Appendix 4.2 C

KCC Water Services Department Meeting Notes

Notes from Pre-planning Technical Meeting between DOB&A and KCC WSD

Project:		Herbata Data Centre, Halverstown , Naas	
Project No.:		DOBA 2232	
Date:		11.04.2023 11.15 am	
Venue:		Microsoft Teams	
Attendees:			
	Kehinde Oluwatosin	KCC Planning	KO
	David Hall	KCC WSD	DH
	Donnachadh O’Brien	Donnachadh O’Brien & Associates	DOB
	Richard Kiernan	Donnachadh O’Brien & Associates	RK
	Martin Forte	Donnachadh O’Brien & Associates	MF
	David Bosonnet	Brady Shipman Martin (Landscaping)	DB

- NOTES:**
- DO NOT SCALE OFF THIS DRAWING. ALWAYS WORK TO NOTED DIMENSIONS.
 - ALL DIMENSIONS MUST BE VERIFIED ON SITE BEFORE COMMENCING WORK. DISCREPANCIES MUST BE REPORTED TO THE ENGINEER.

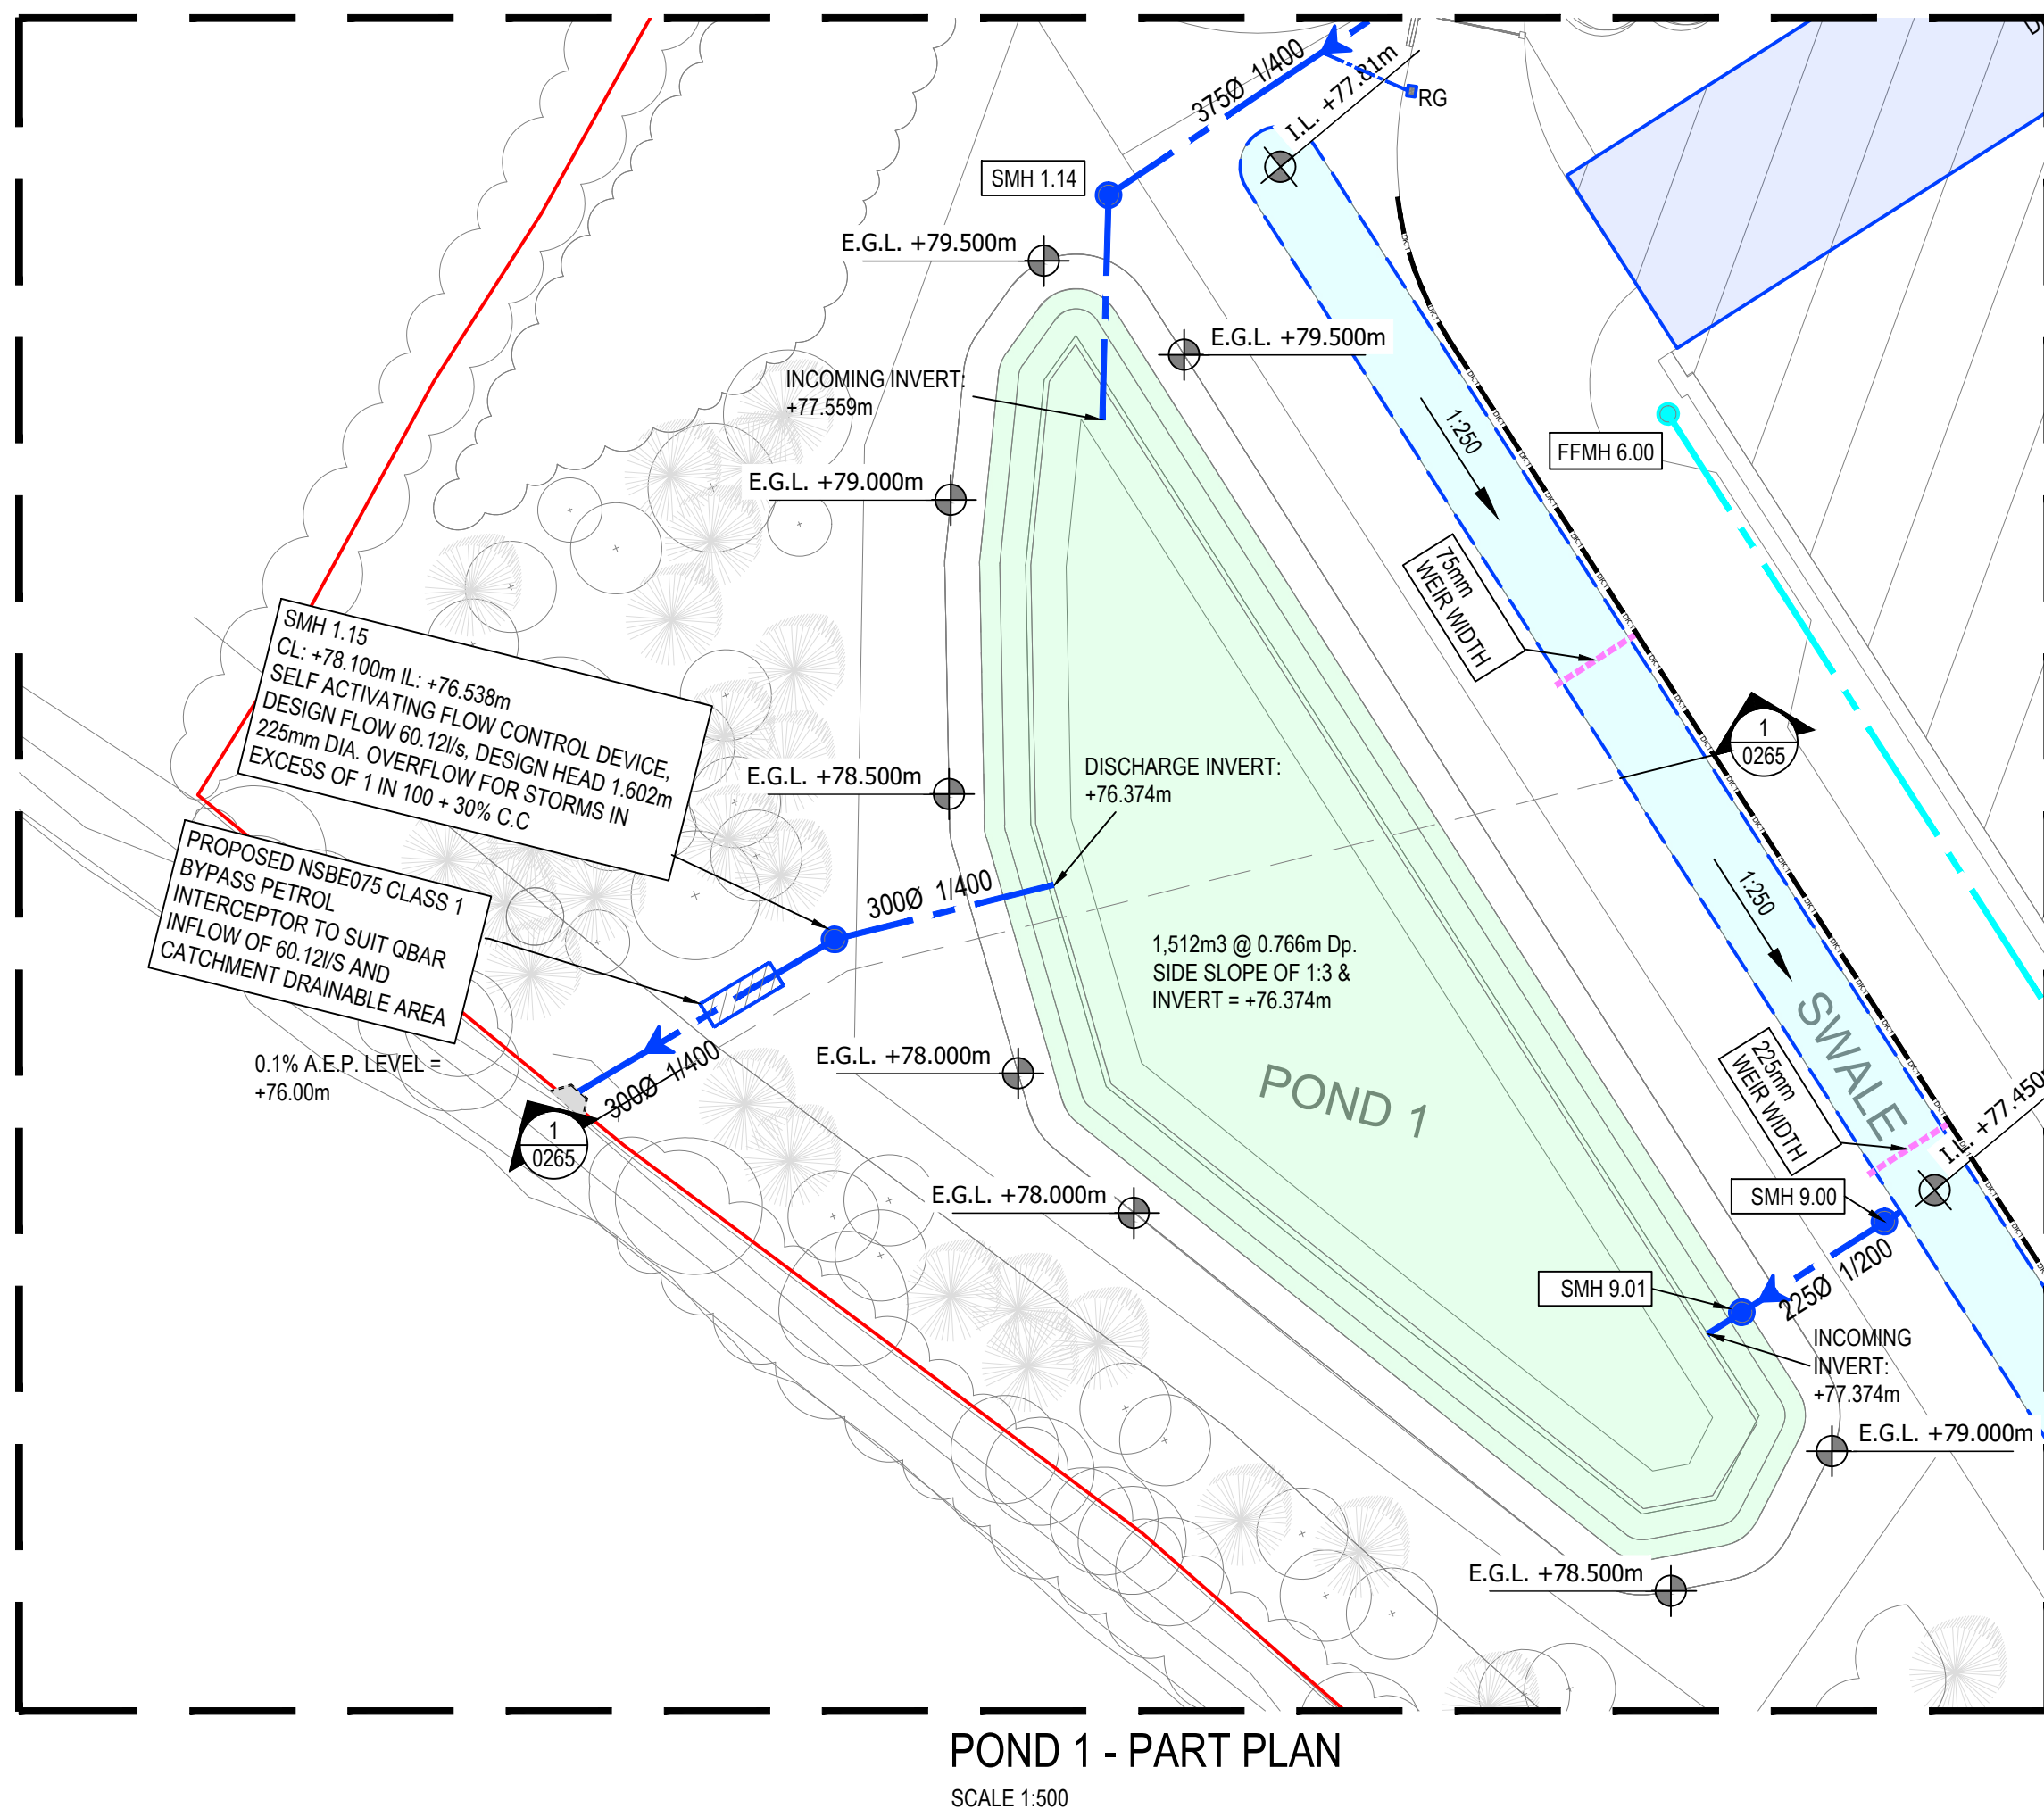
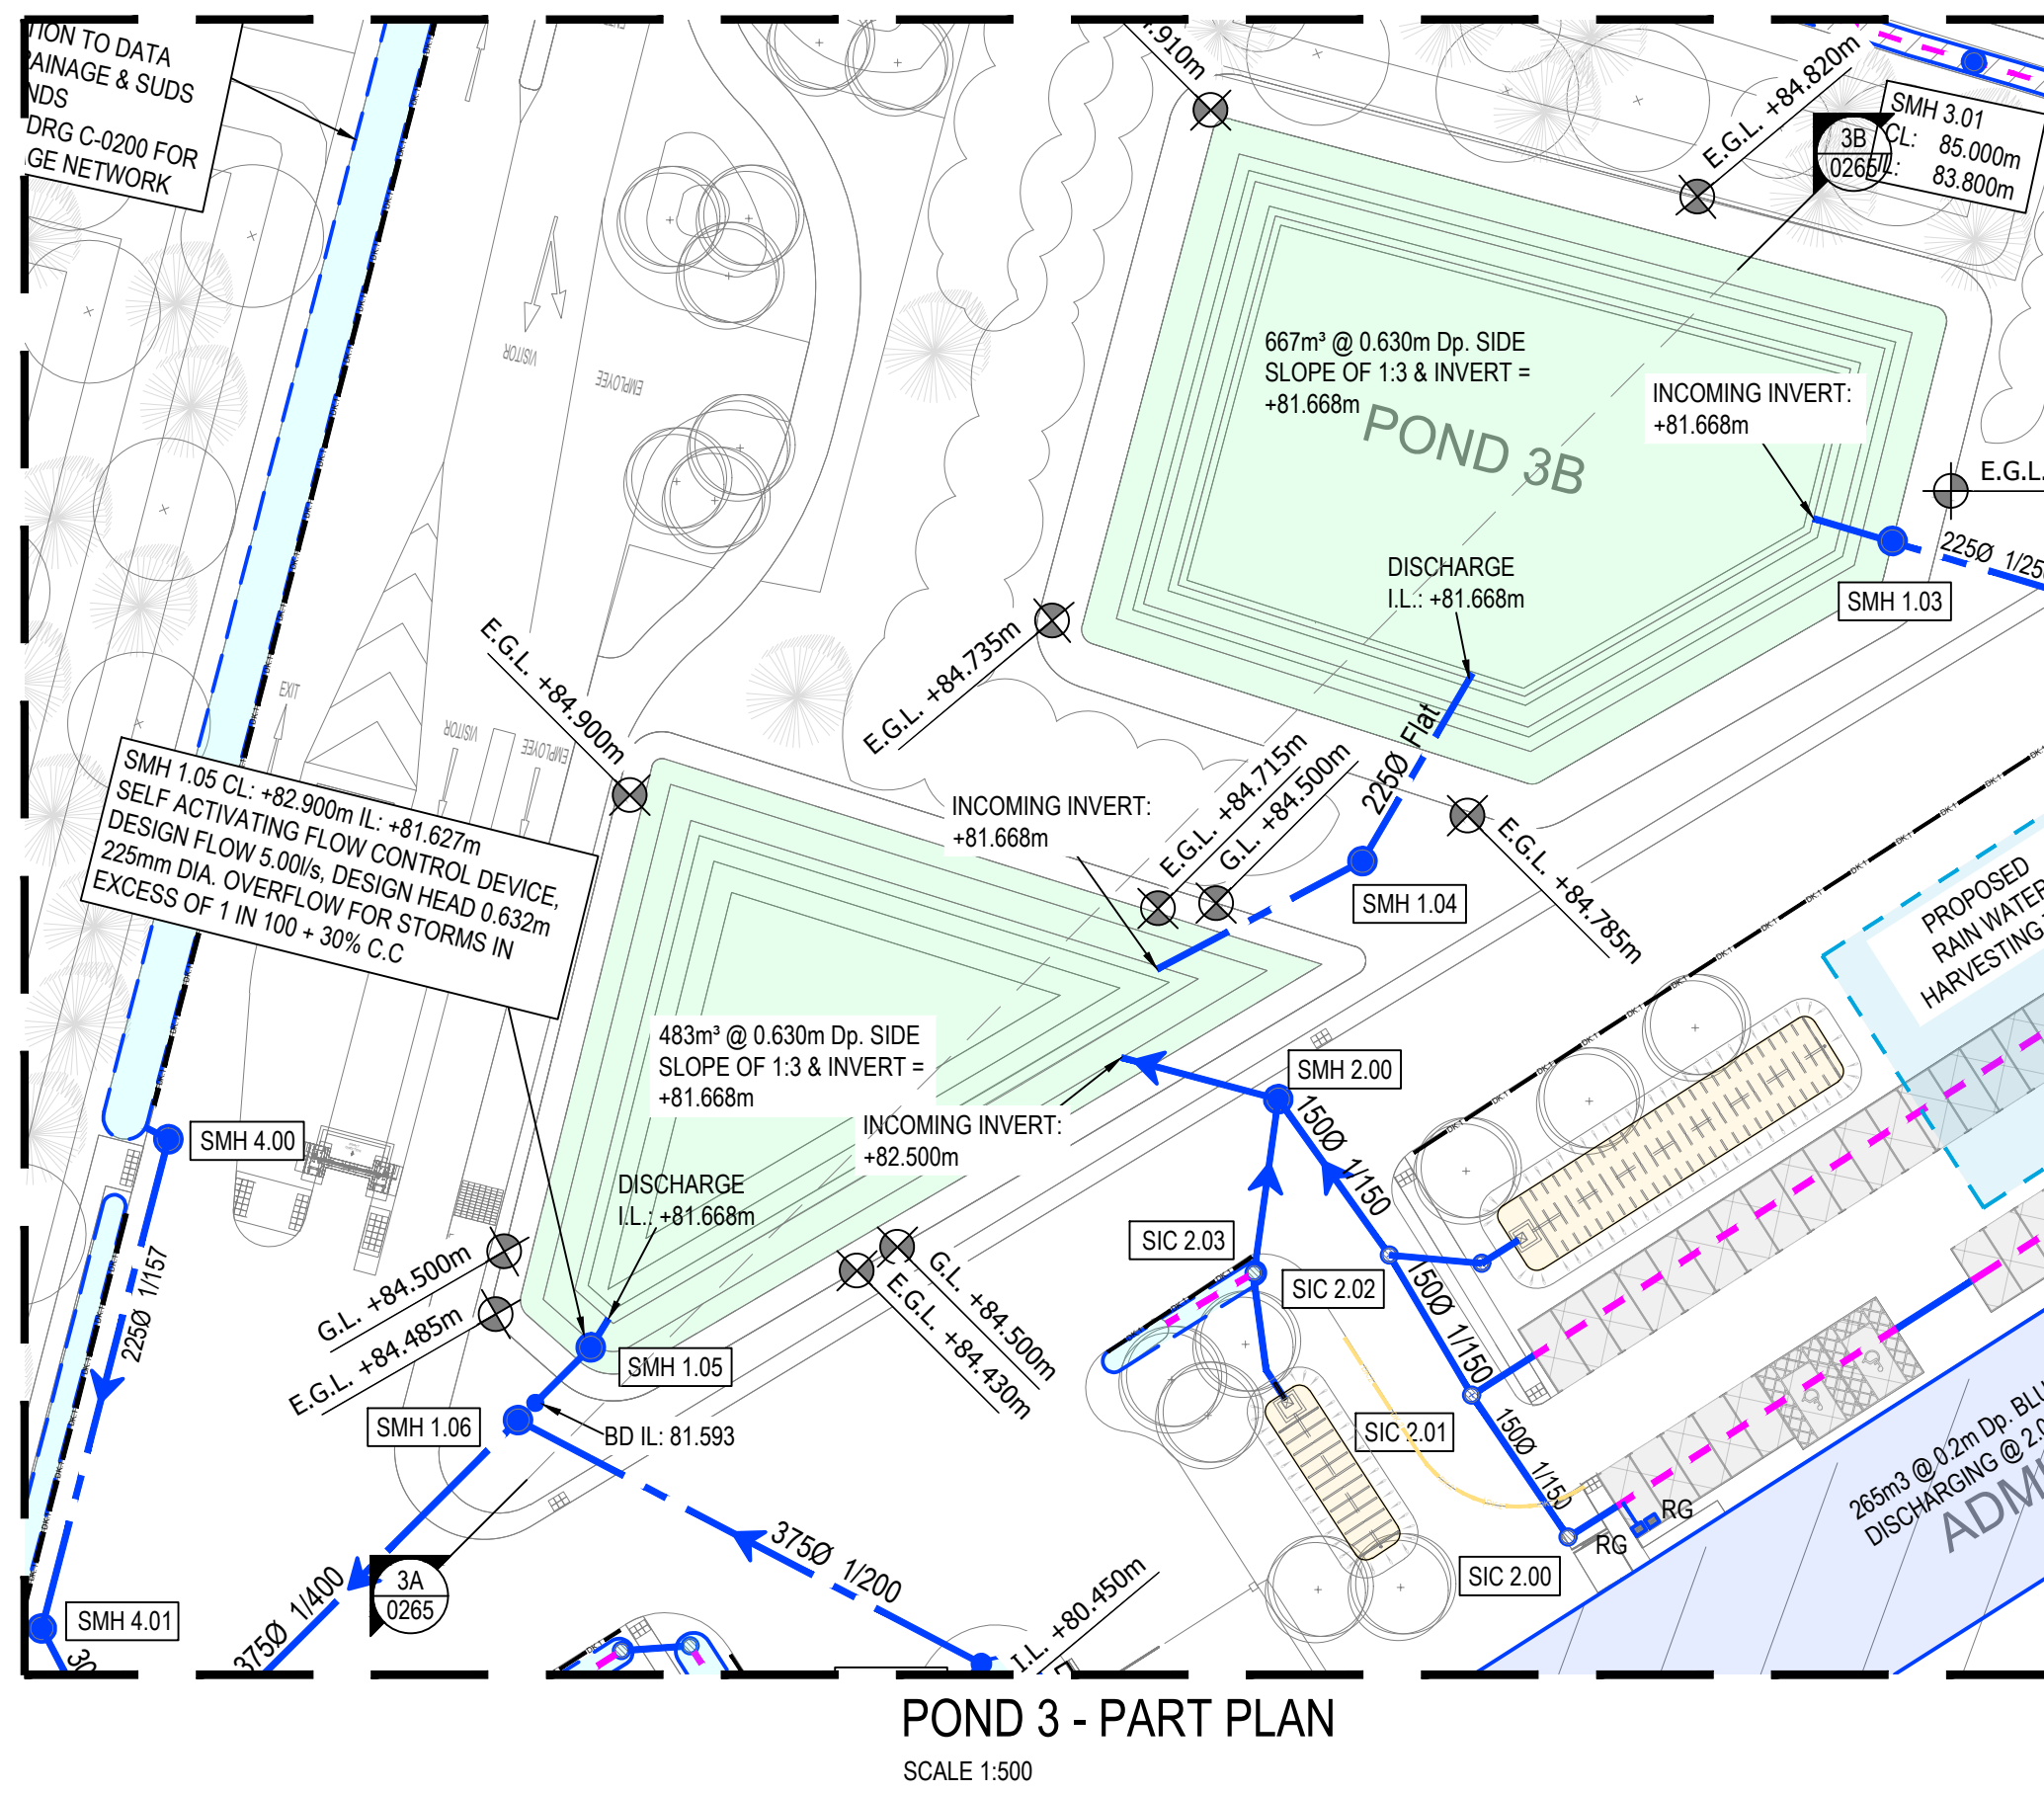
- Discharge of water direct to swales from internal road network by use of dropped kerbs. DOB showed a typical section noting this is being adapted. Roadside bioswales should also convey runoff where possible.
